Response to Comments

3845 Cambrian Road

**RE: Response to Comments
3845 Cambrian Road
Site Plan Control (D07-12-23-0058)**

DRAWING NO. **A001.2**

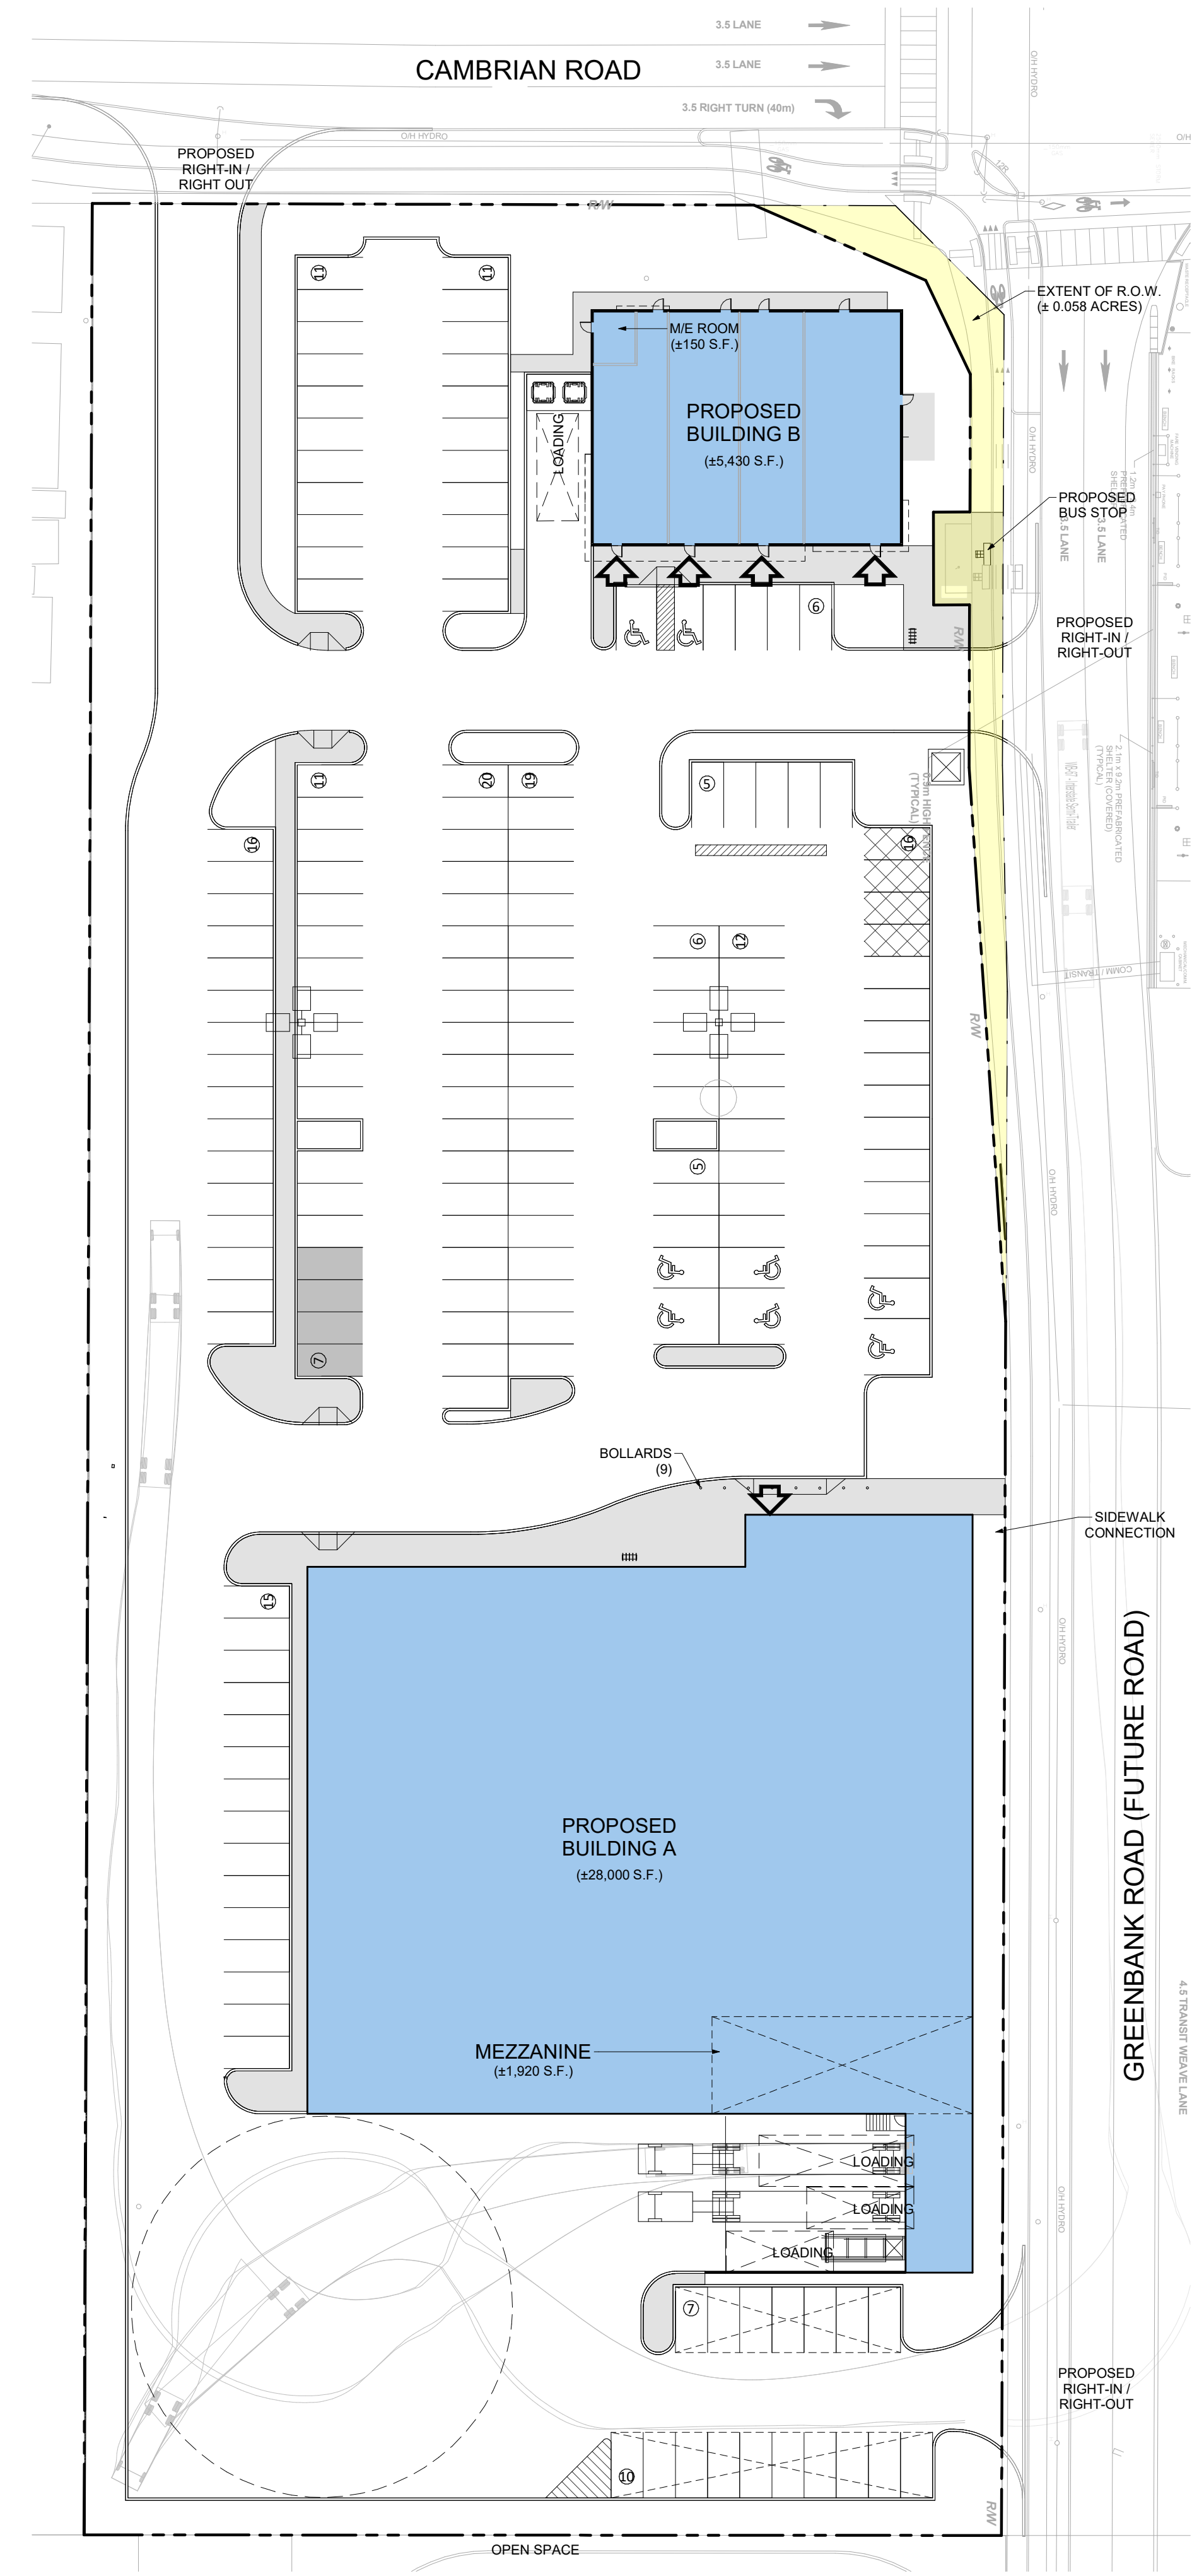
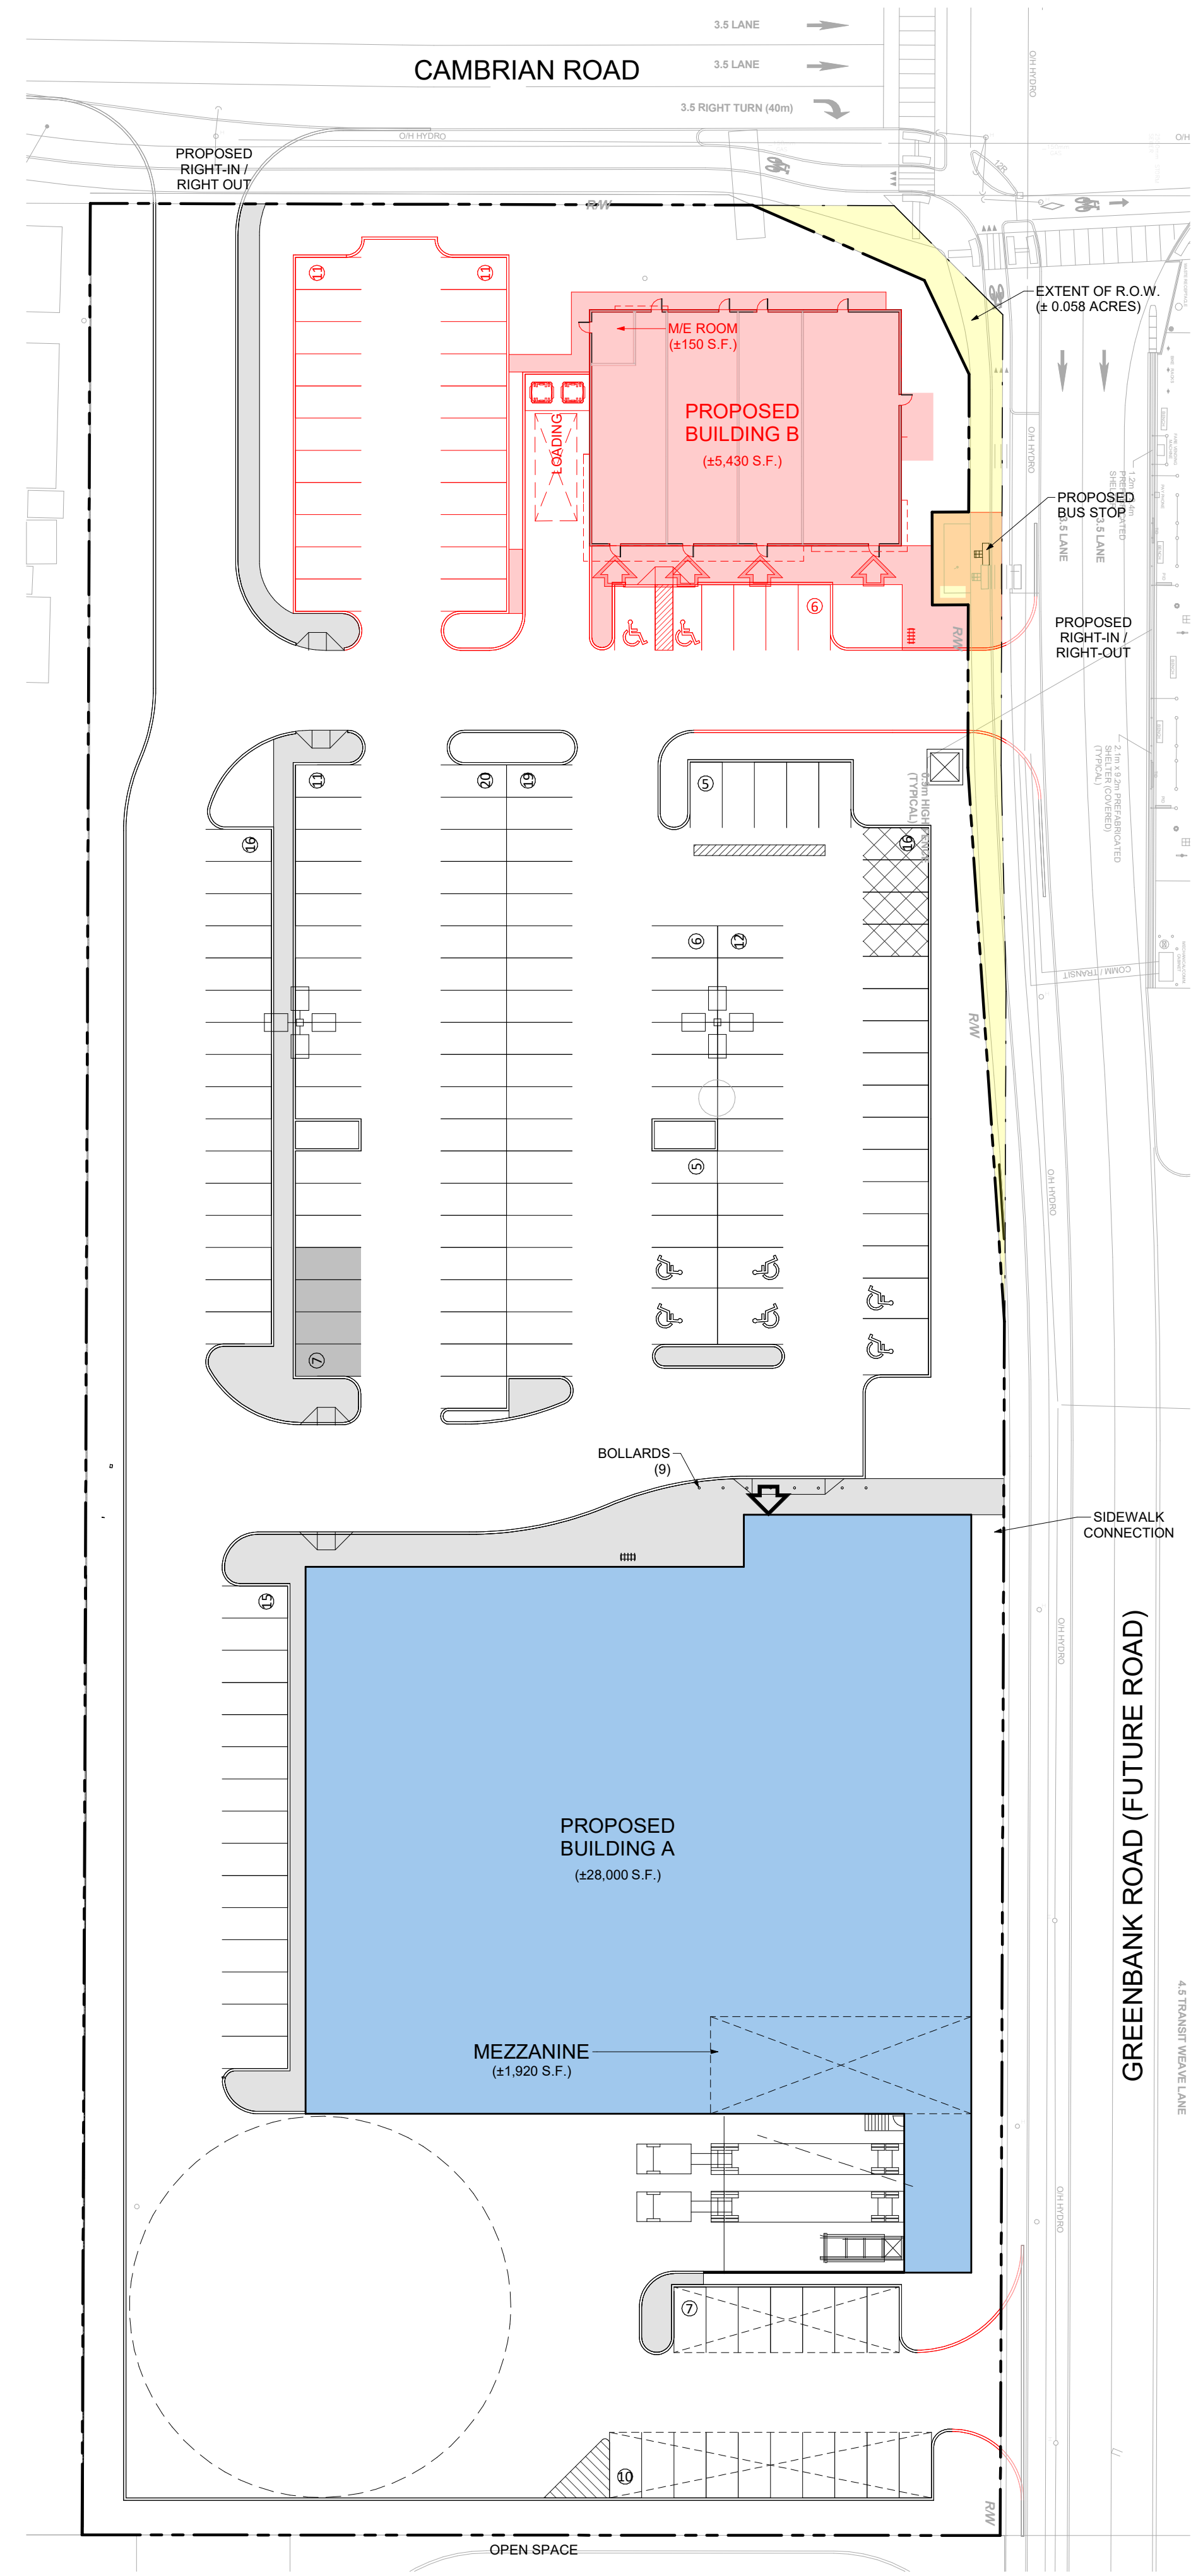
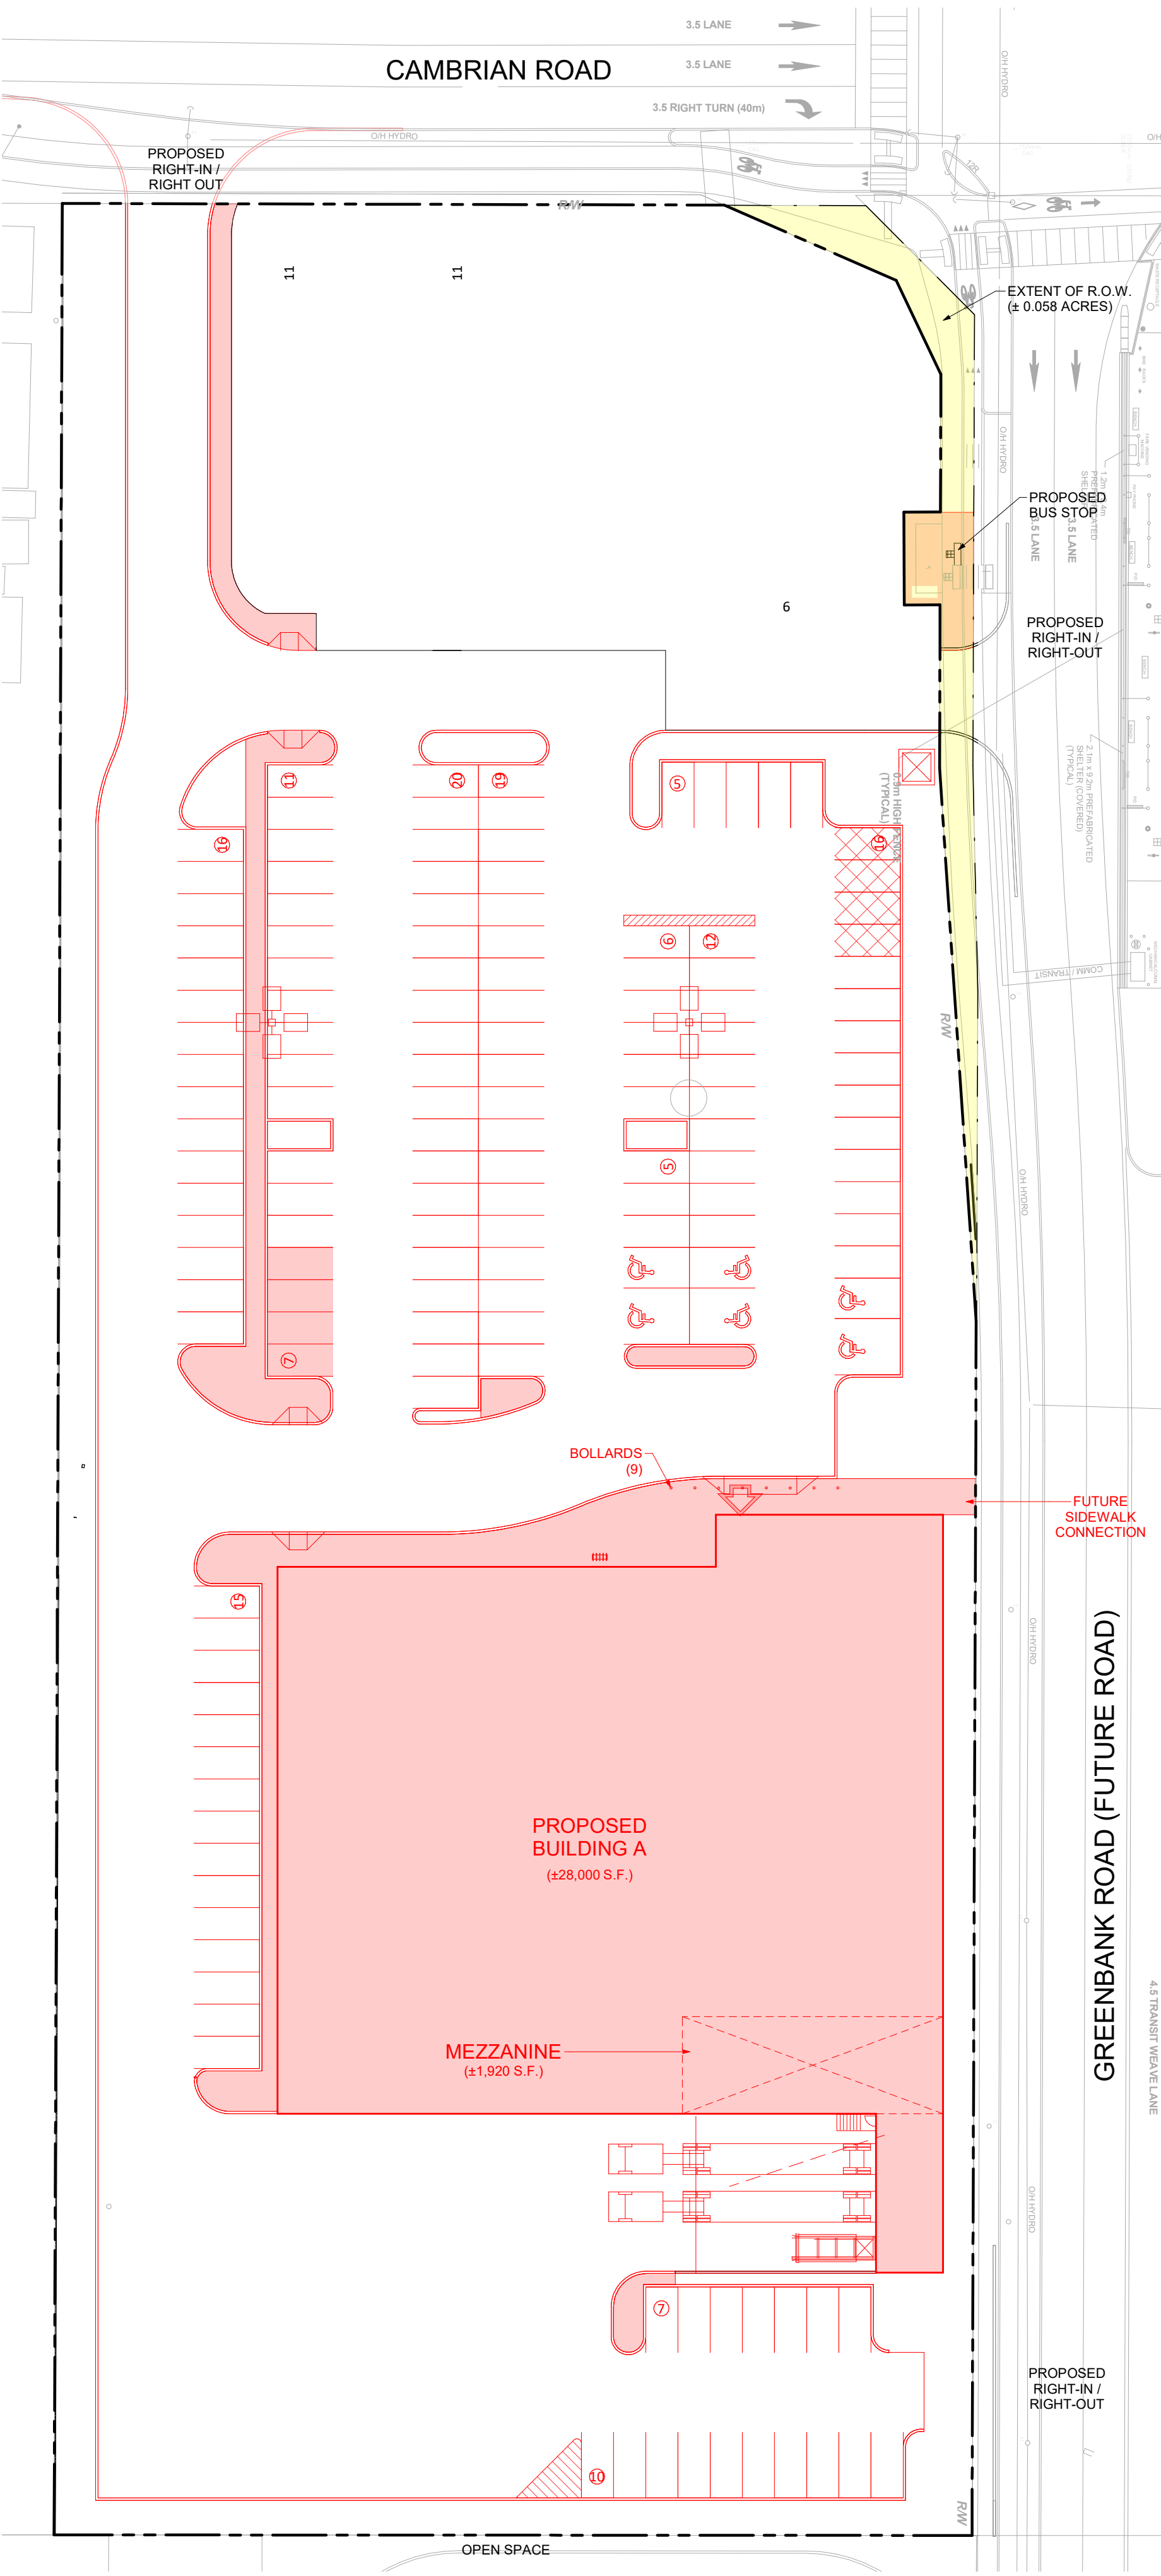
2.3. Provide an interim site plan and ultimate site plan (i.e., Greenbank Road realignment, right-in/right-out accesses etc.).

- 4.4. Building on comment #4.8 in the 1st Review Comment Letter, please provide a site plan showing the current/interim condition and a separate site plan showing the ultimate condition (i.e., two right-in/right-out accesses on Cambrian Road and Greenbank Road). The site plan showing the current/interim condition will be stamped with the site plan control approval. This site plan should include a curb and/or hammer head for the second access and a notation (i.e., future access on Greenbank Road).

Response: Site plan drawing A001.2 illustrates the phasing, interim conditions, and final conditions

Response: Site plan drawing A001.2 illustrates the phasing, interim conditions, and final conditions.

4 NORTH ELEVATION
A301 1:150

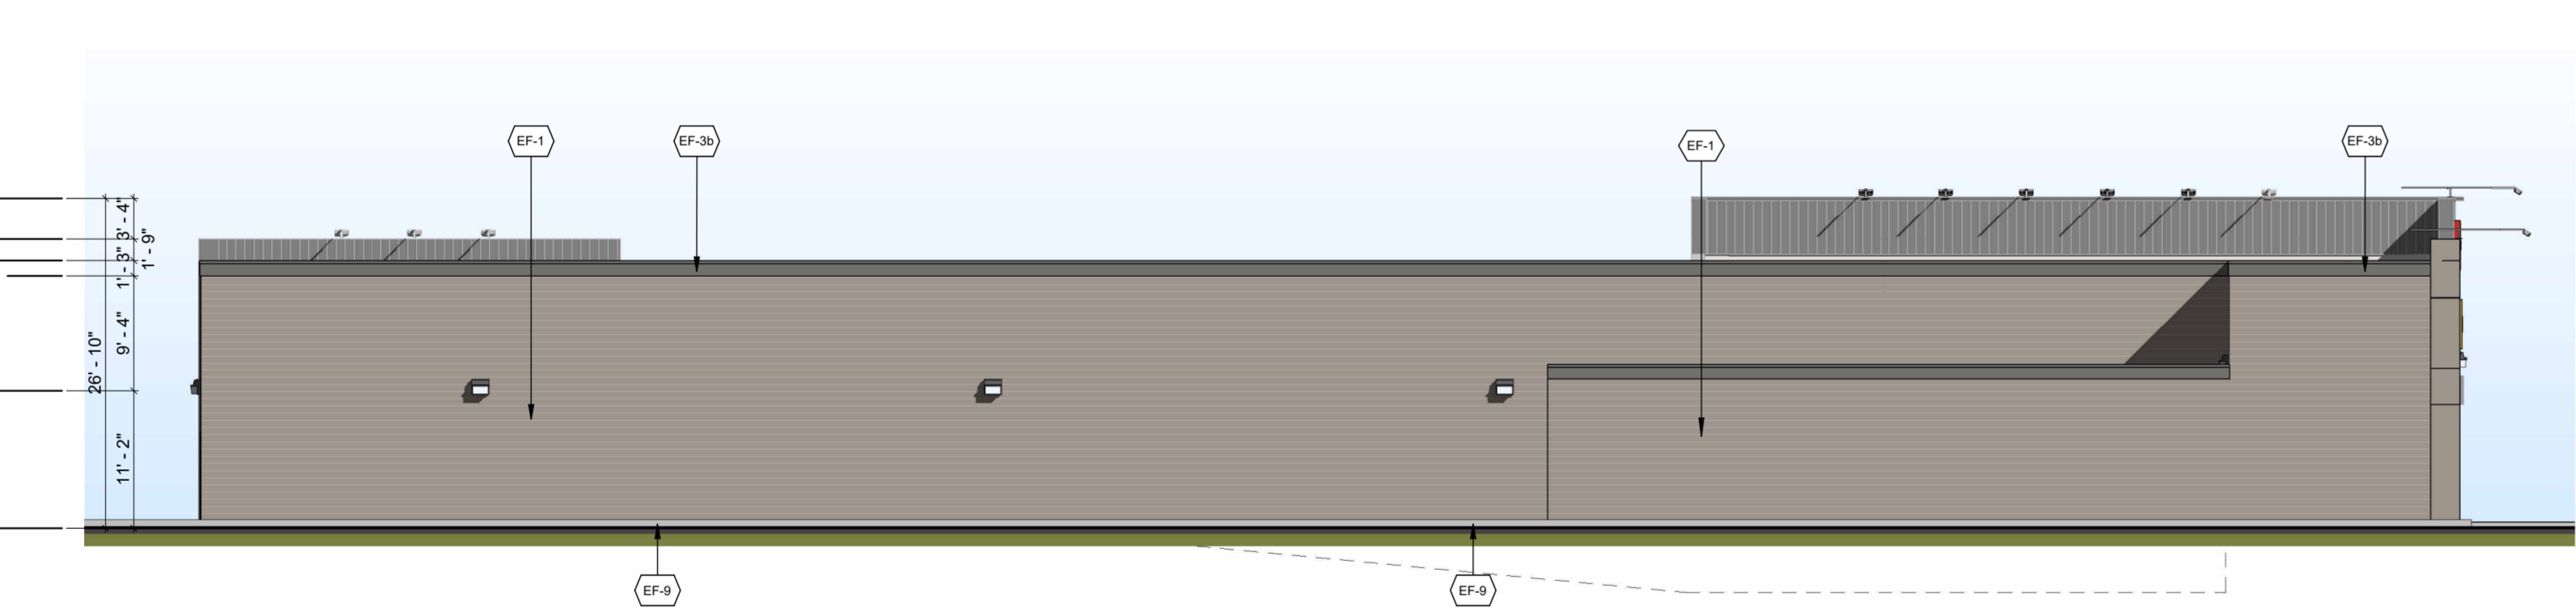
5.6. Animation along Greenbank and Cambrian Road is needed. Consider providing windows (yellow) display windows (red) instead of areas for decals as shown below. Please consider extending the black awning to the Greenbank façade for continuity. Further to the comment above, explore the potential for further glazing and principle access' along Cambrian and Greenbank for Building B.

Response: Refer to comment 5.1
